**CITY OF ALBUQUERQUE
PLANNING DEPARTMENT
Development Review Board
July 23, 2003 Comments**

Project: 1002813 Application: 03DRB-01162

RE: Sundoro South

SUNDORO SOUTH			
SKETCH PLAT			
		MARK GOODWIN & ASSOCIATES, P.A. CONSULTING ENGINEERS	
P.O. BOX 90606 ALBUQUERQUE, NEW MEXICO 87199 (505)828-2200, FAX (505)797-9539			
Designed: JDH	Drawn: KJS	Checked: DMG	Sheet 1 of
Scale: 1" = 100'	Date: 07-11-03	Job: A03070

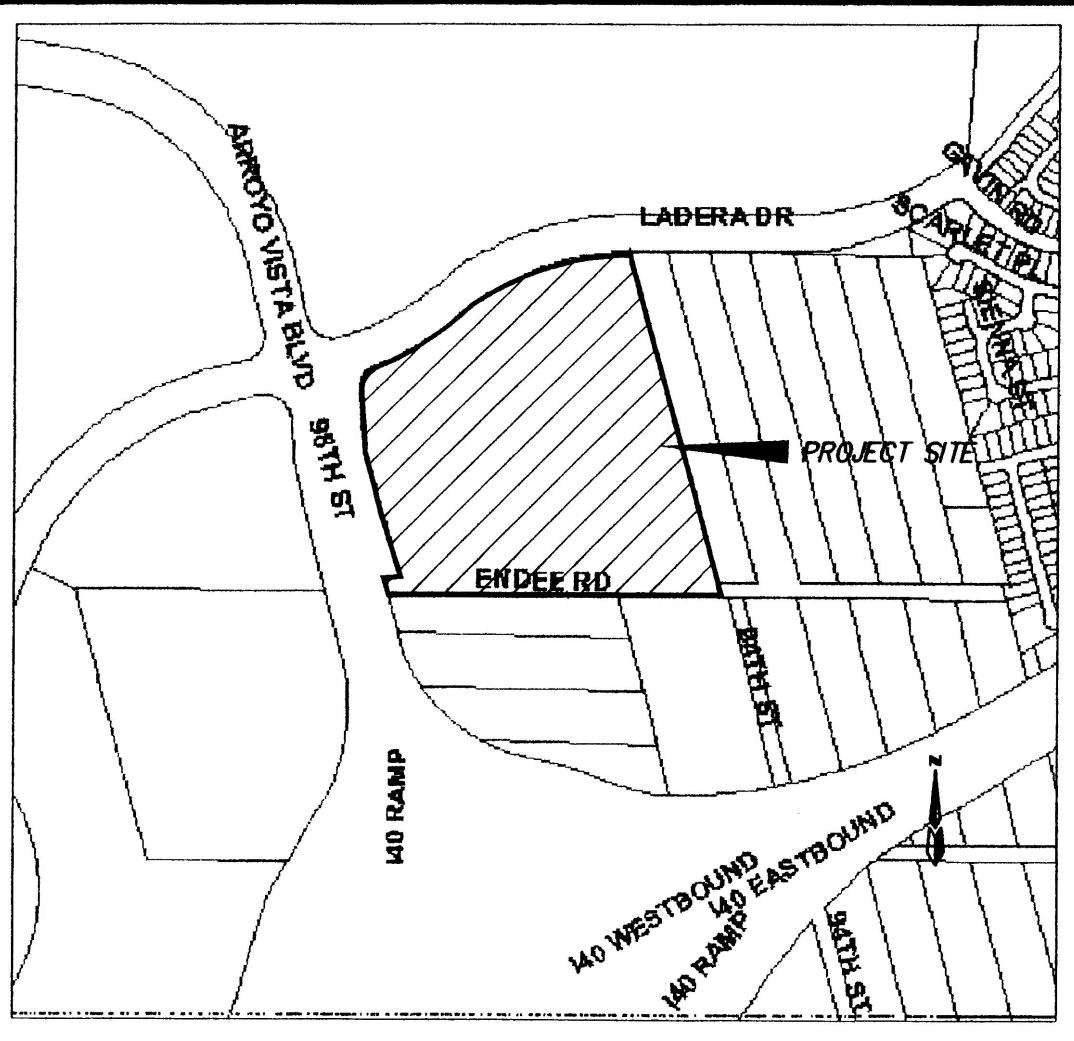
Parcel 1 is within the Westland Master Plan & Sector Plan boundaries. Be sure to follow these plans' policies, regulations, etc as you develop your Site Plans.

No.	Comment
<input type="checkbox"/>	The standard street improvements are required on an infrastructure list.
<input type="checkbox"/>	The streets need to meet the requirements of the DPM.
<input type="checkbox"/>	A traffic distribution layout is needed.
<input type="checkbox"/>	How do the parcels to the south obtain access?
<input type="checkbox"/>	Does this development follow an approved TIS? Have off-site mitigation been addressed?

An approved Drainage Management Plan (DMP) for the entire basin is required for preliminary plat approval.
 An approved infrastructure list is required for Preliminary Plat approval.
